DEVELOPMENT REVIEW BOARD
SUPPLEMENTAL SUBMITTAL

PROJECT NO. 2018-001579
Application No. SI-2020-01477

SUBMITTAL DESCRIPTION: Departmental comments indicated a number of items to be addressed in a deferred hearing date, indicated above for multi-family apartments project at 7500 Indian School Rd in the Winrock Town Center. Responses to the comments and revised sheets are provided.

This letter outlines the modifications that have been made to the Apartments at Pennsylvania St and Indian School Rd application for a major site plan amendment to the approved Winrock Town Center Site Development Plan (PR-2018-001579) to address the agency comments that were received.

**CONCEPTUAL UTILITY PLAN**

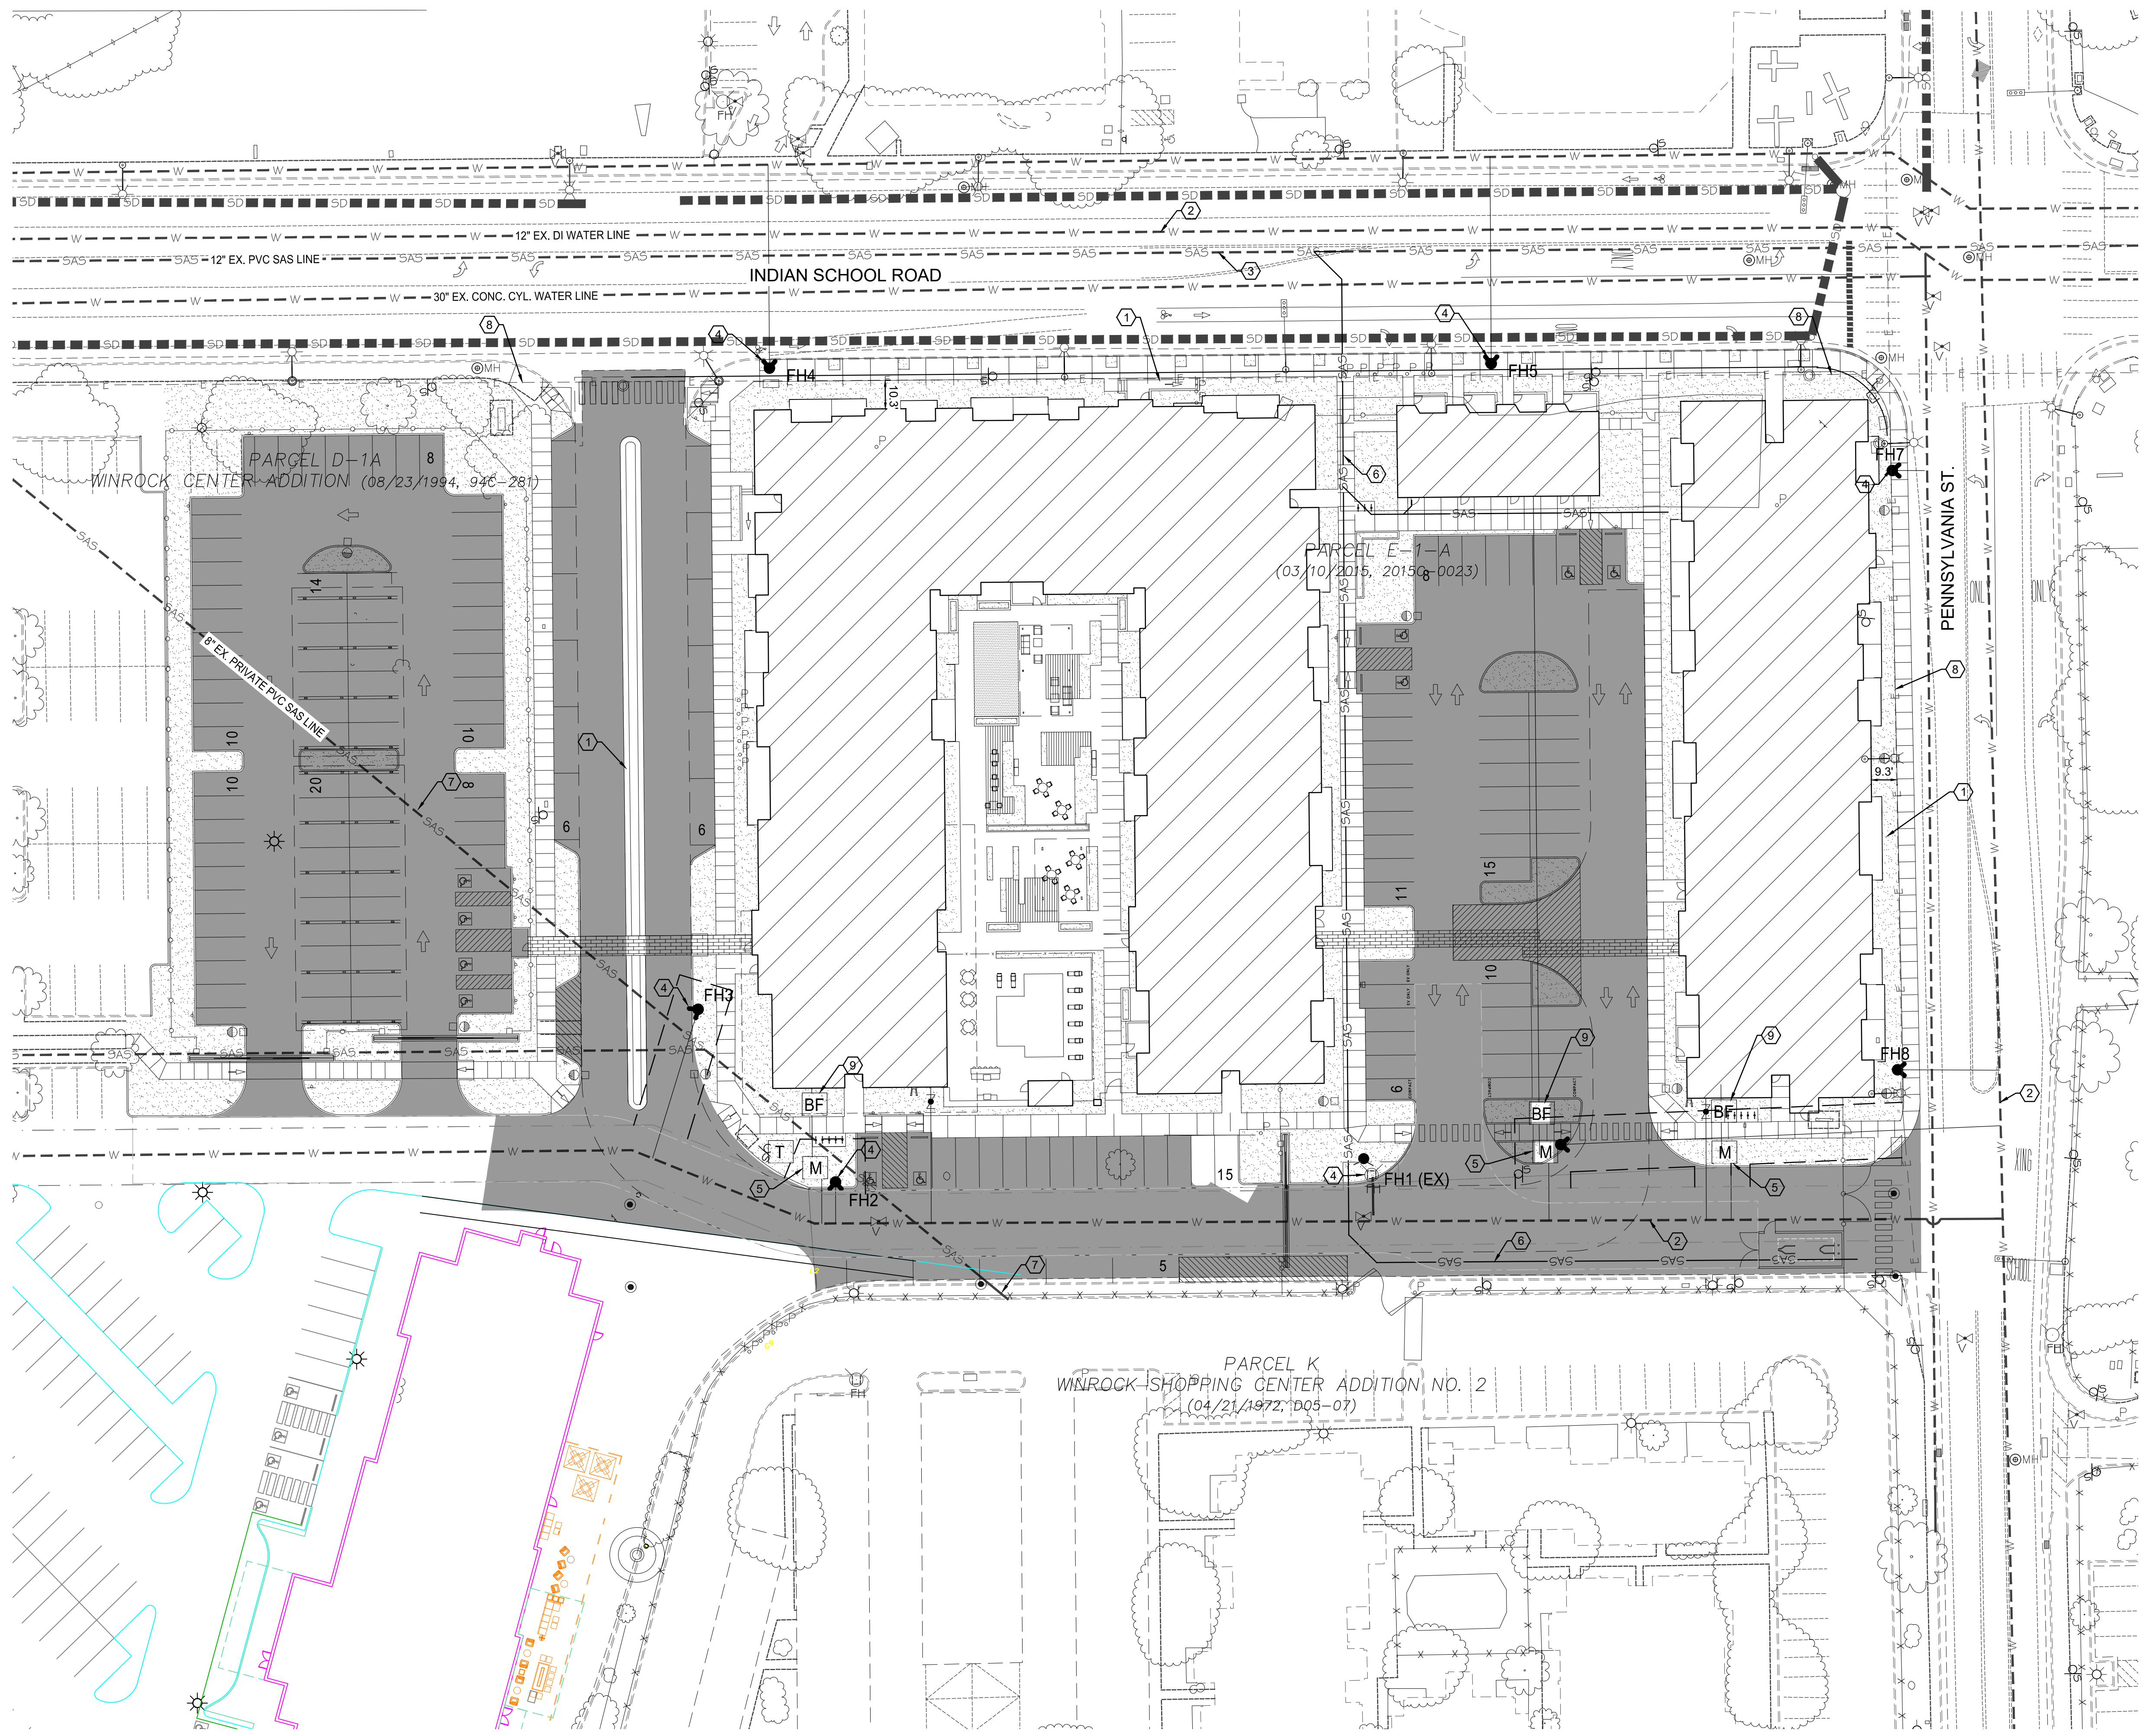
- b. Conceptual Utility Plan (stamped/signed 4/9/21)
 - i. Please review keyed notes and ensure they are appropriate as the Enlarged Utility Plan has some incorrect references and keyed notes.

Keyed notes updated.
